Ribble Valley Borough Council
Housing & Development Control

Application no: **3/2023/1008**

Address: **Wellsprings Hotel Clitheroe Road Sabden BB7 9HN**

Proposal: **Proposed refurbishment of existing ground-floor caretaker apartment and creation of four new holiday let apartments, three on the ground floor and one on the first floor.**

Application No:
 Local area council:
 Previous application No:
 Dwg : PCD00154
 Drawn: PCD

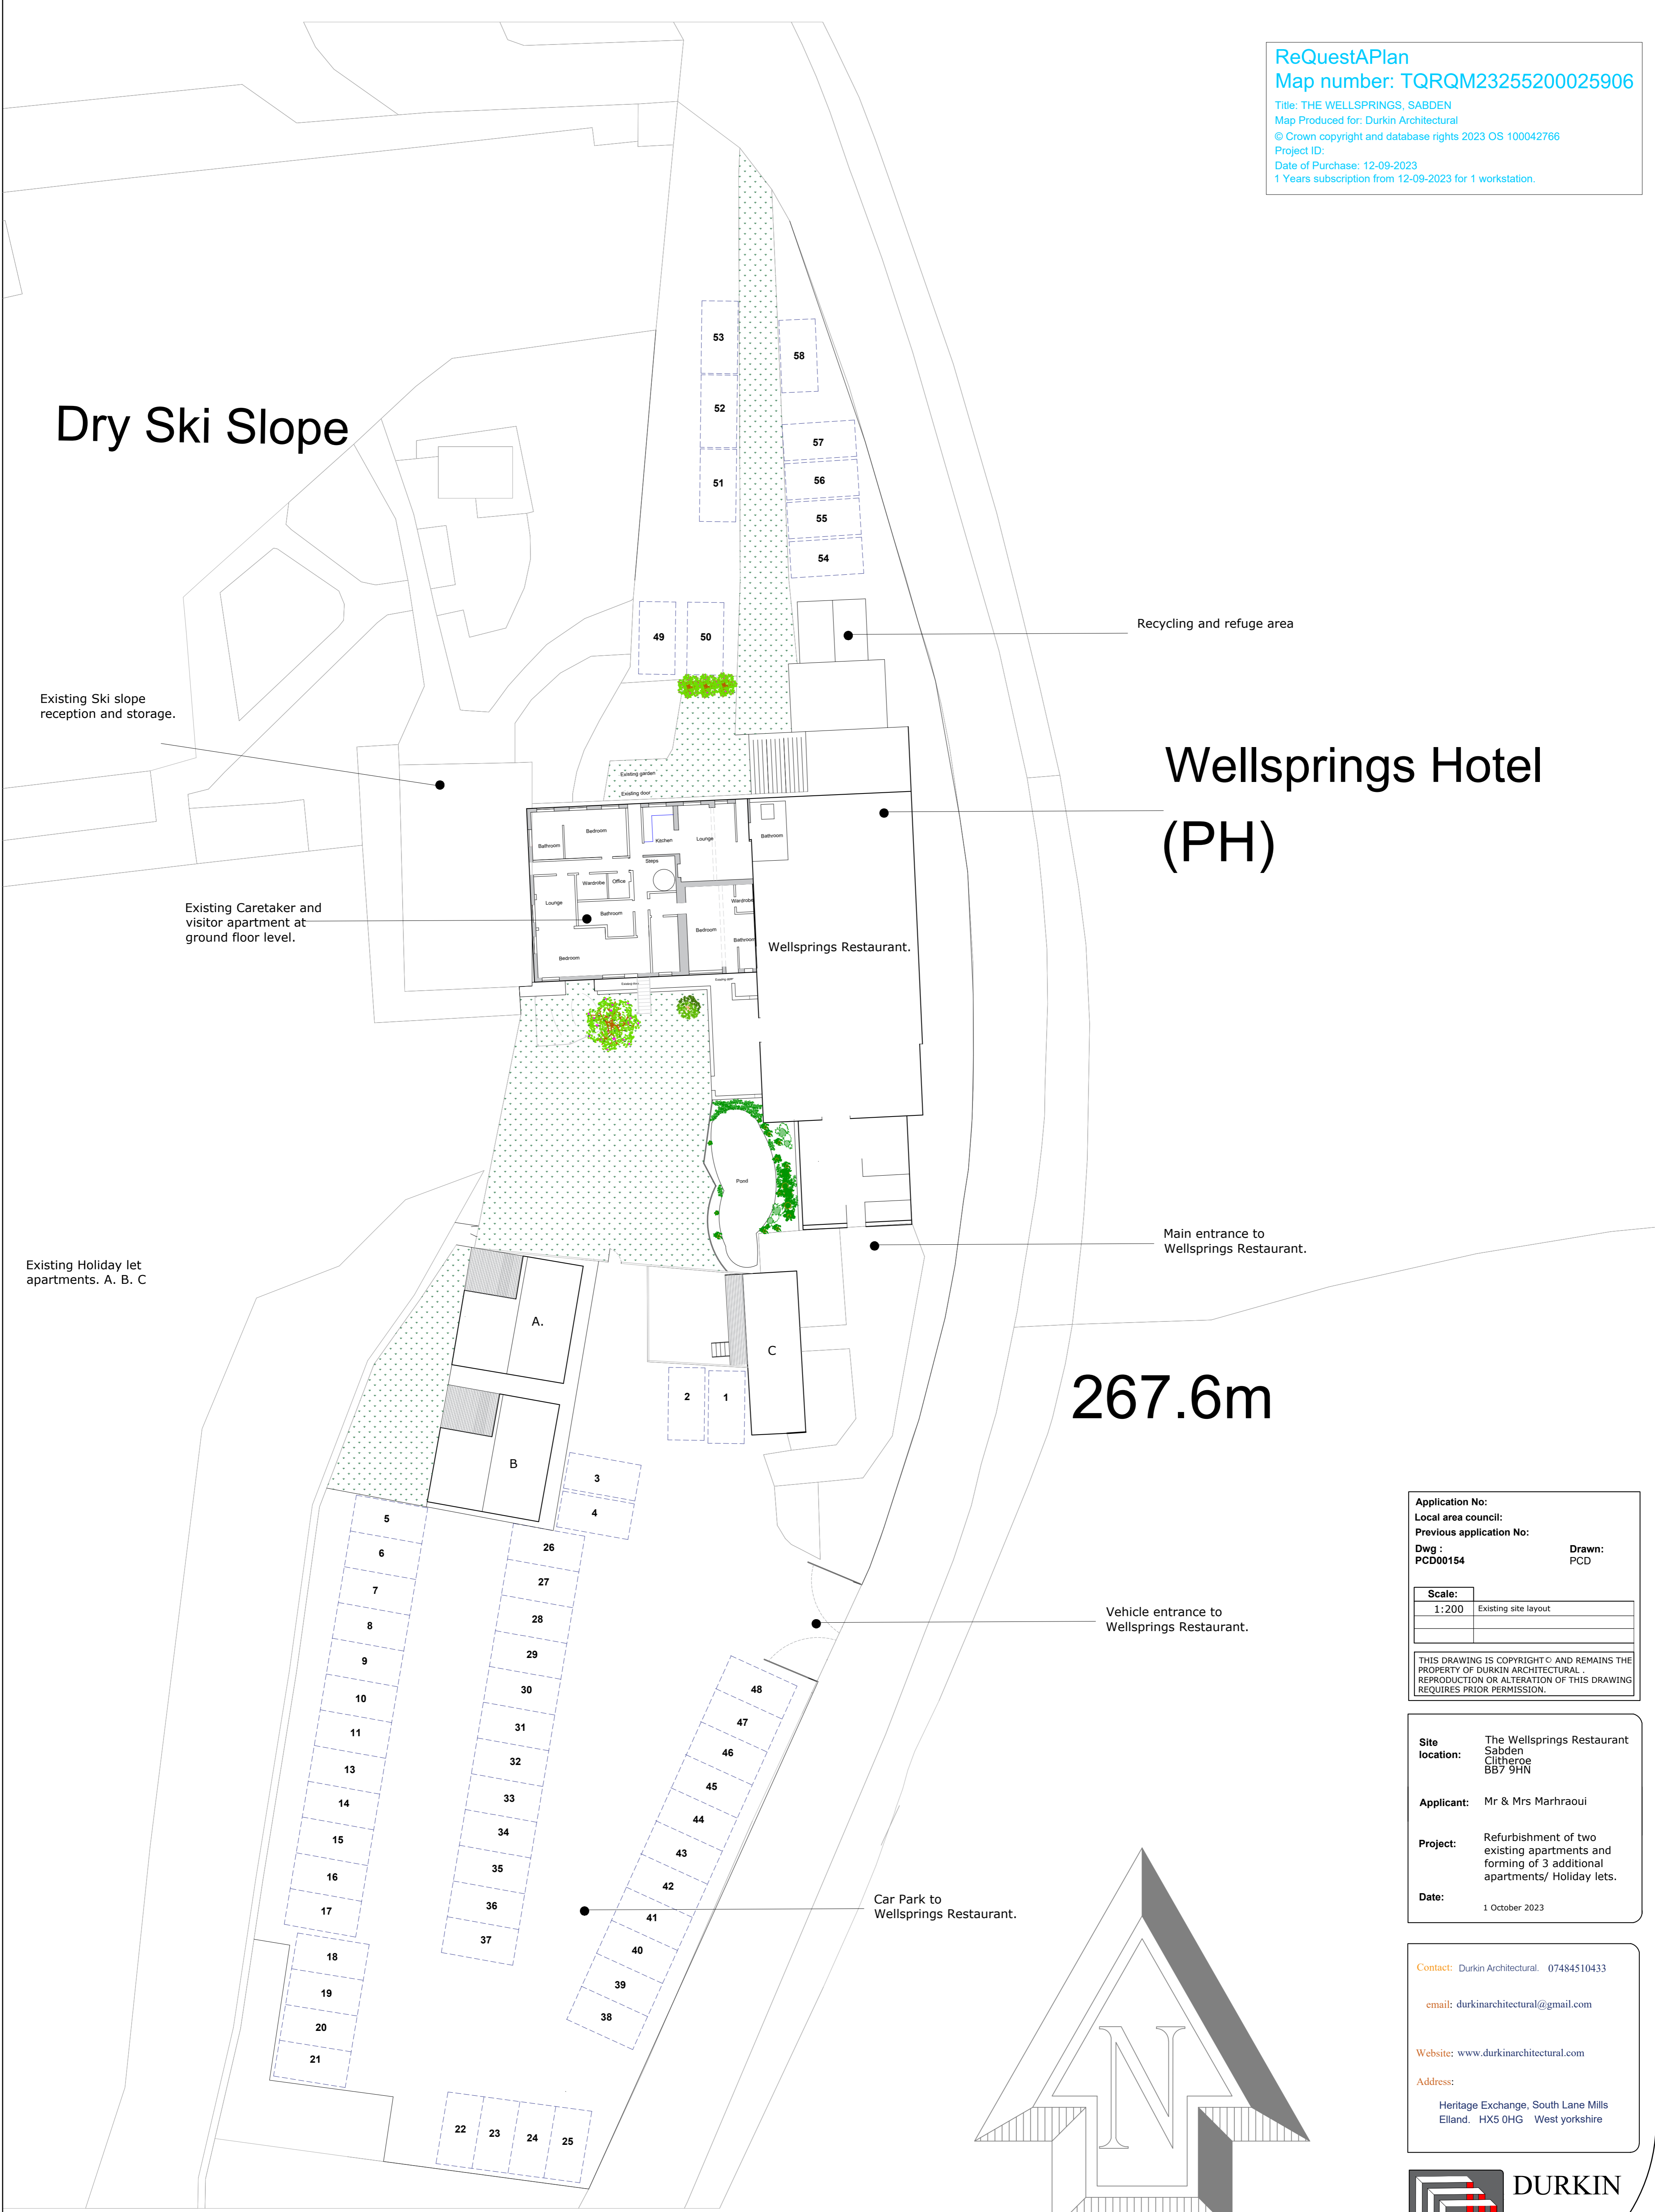
The site has two car parks which are provided off Clitheroe Road, a C classified road subject to a 60mph speed limit. The main car park is used for the customers of the Wellsprings Restaurant and the two existing holiday lets providing 48 car parking spaces. While the other car park provides upto 10 car parking spaces, with 5 being provided by the roadside and the other 5 via a separate access leading to the lower parking area, as shown on Durkin drawing number PCD00154 titled "Existing Site Layout".

The LHA have firstly reviewed the alterations to the access which serves the lower parking area. The area is currently used as a car park for employees and servicing vehicles. Following the proposal, the access to the car park will be widened. However, the LHA are unable to support any additional widening of this area which could potentially lead to the formalisation of this car parking area. This is because there is a lack of internal space for vehicles and in particular servicing vehicles to turn and exit the site in a forward gear. This is in a location which has limited visibility in both directions and is located off a high speed classified road. Therefore, the LHA require these improvements to be removed from the proposal and strongly advise that employees and servicing vehicles use the main car park for highway safety reasons.

Adjacent to the lower parking area, as already mentioned, there is an area of roadside parking which is used by employees. While this roadside parking is not ideal with there again being limited visibility and turning areas to exit the area in a forward gear, the area is likely to be considered lawful with it being in use for a considerable amount of time. Therefore, to ensure that the area is adequately surfaced, the LHA will request that a surfacing improvement scheme is provided subject to a Section 278 Agreement.

- Revised Operation Statement detailing the expected number of covers on the first floor of the restaurant following the proposal.
- Revised site plan drawing showing that surfacing improvements are made to the existing roadside parking area and any improvements to the access serving the existing lower parking area are removed.
